Development Control
Ribble Valley Borough Council

Re: Planning Application 18/0973

Address: The Avenue Hotel Gleneagles Drive Brockhall Village Old Langho BB6 8AY

Description: Single storey extension to bar and dining area (resubmission of application 3/2018/0533).

PROPOSED SITE LAYOUT 51 CAR SPACES

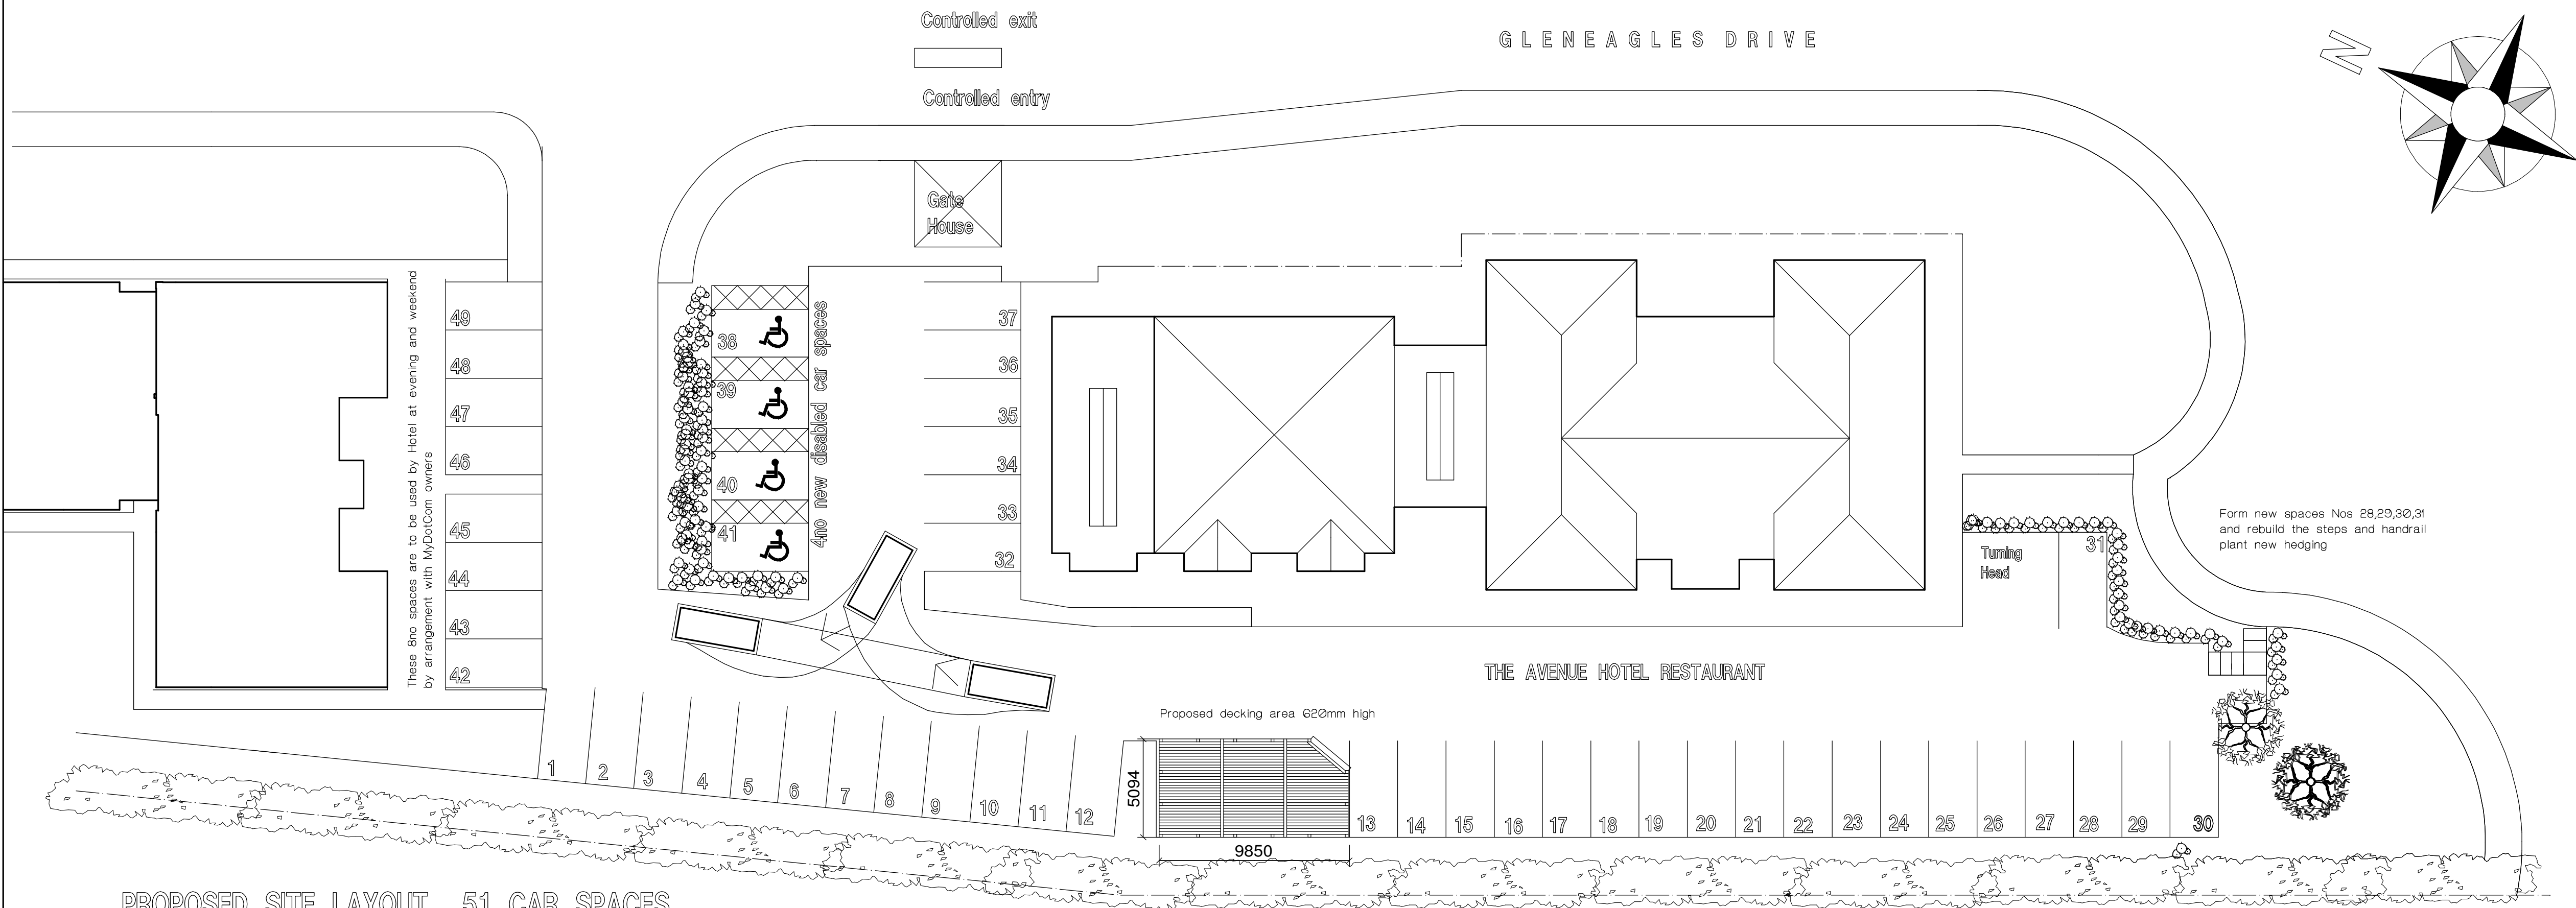
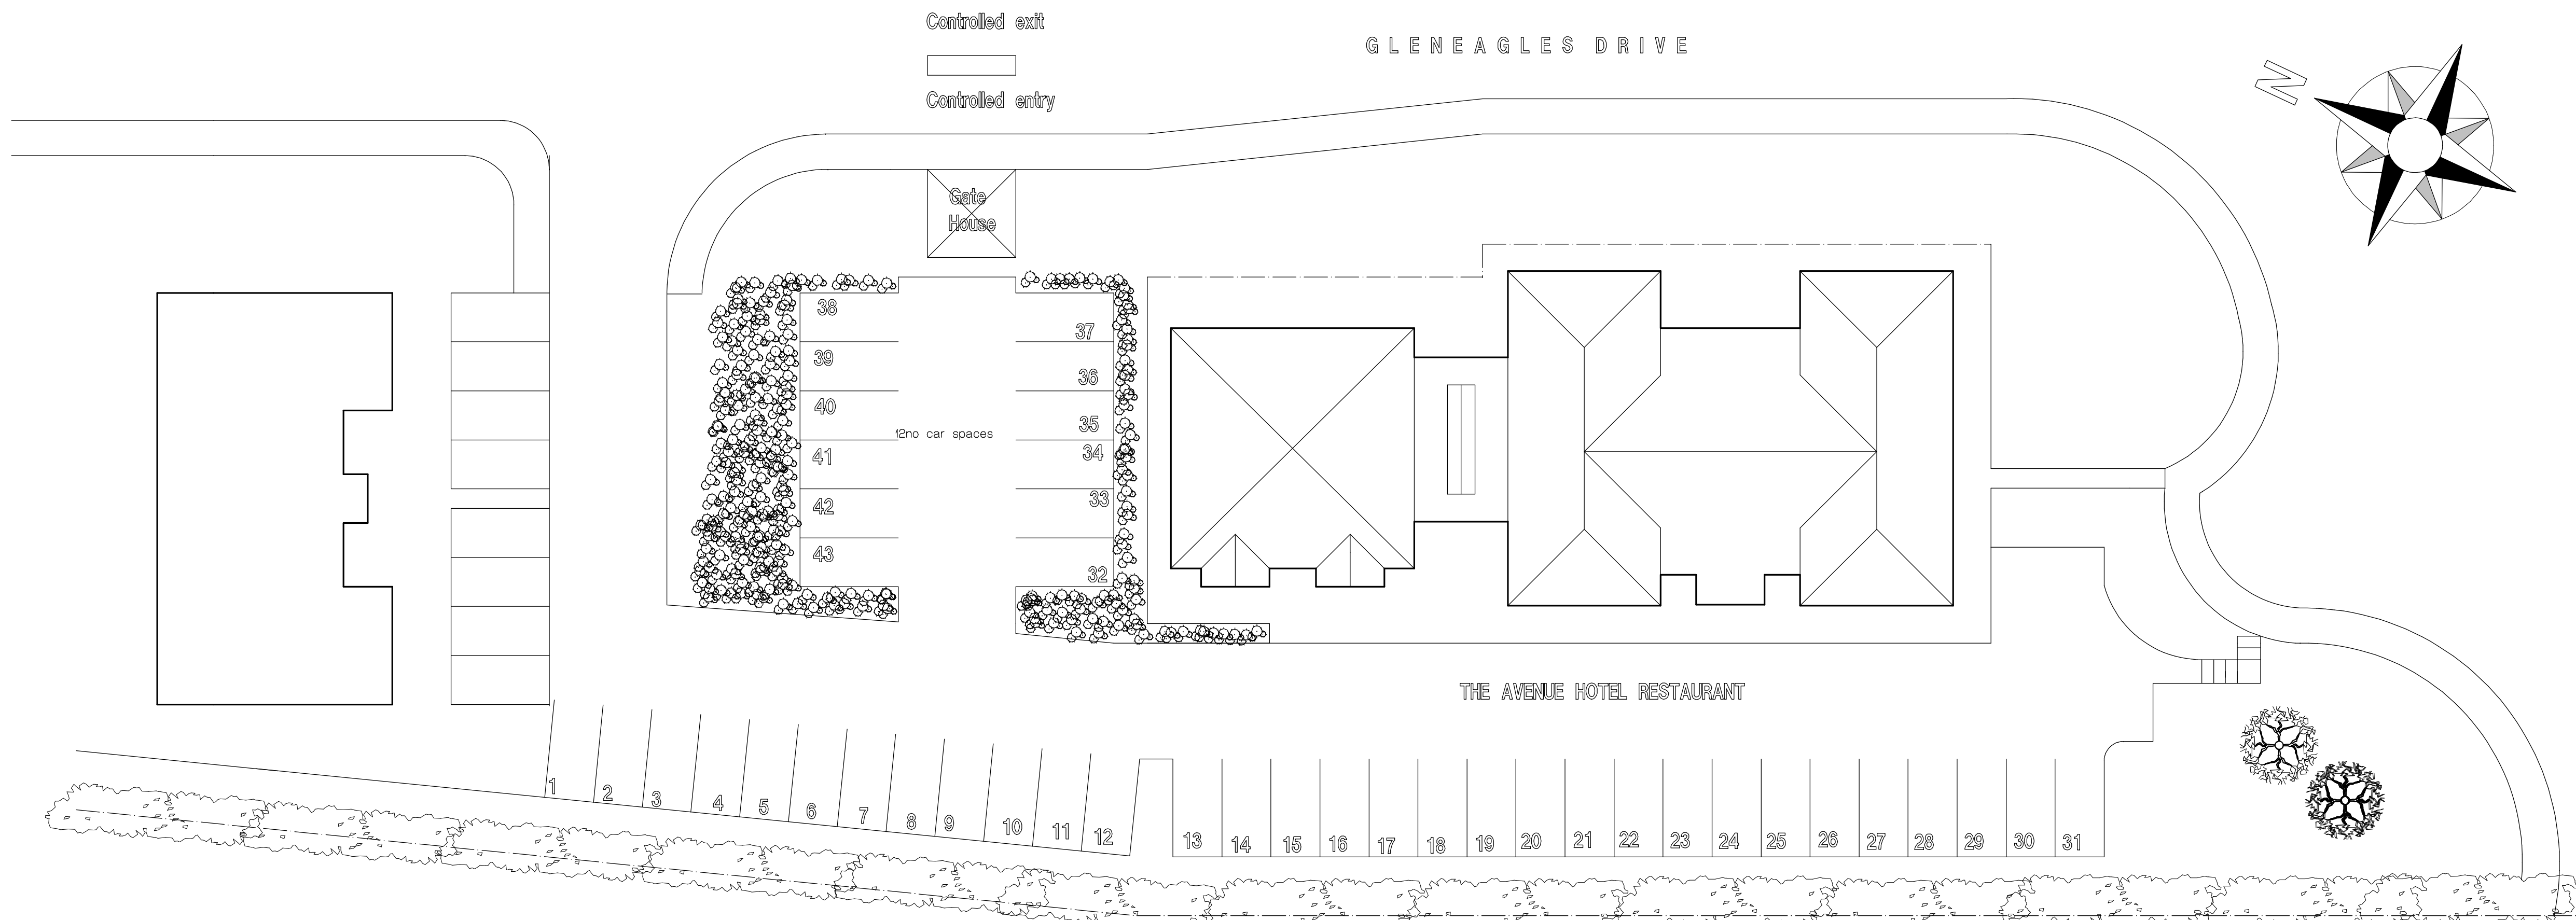
Whilst the applicant has increased the number parking spaces available this is at the detriment of the functionality of the car parking area. The turning head at the end of the car park has been included in the allocation Nos 31-33, which is likely to lead to an increased number of vehicles having to reverse the length of the carpark to enable them to turn around.

It is further noted that there is no provision for any mobility parking, guidance regarding the amount differs although generally, a minimum allocation of 4 marked bays would be expected at a development such as this. Details of the expected requirement including dimensions of the bay and associated hatched area can be found in the Department for Transport's publication Inclusive Mobility.
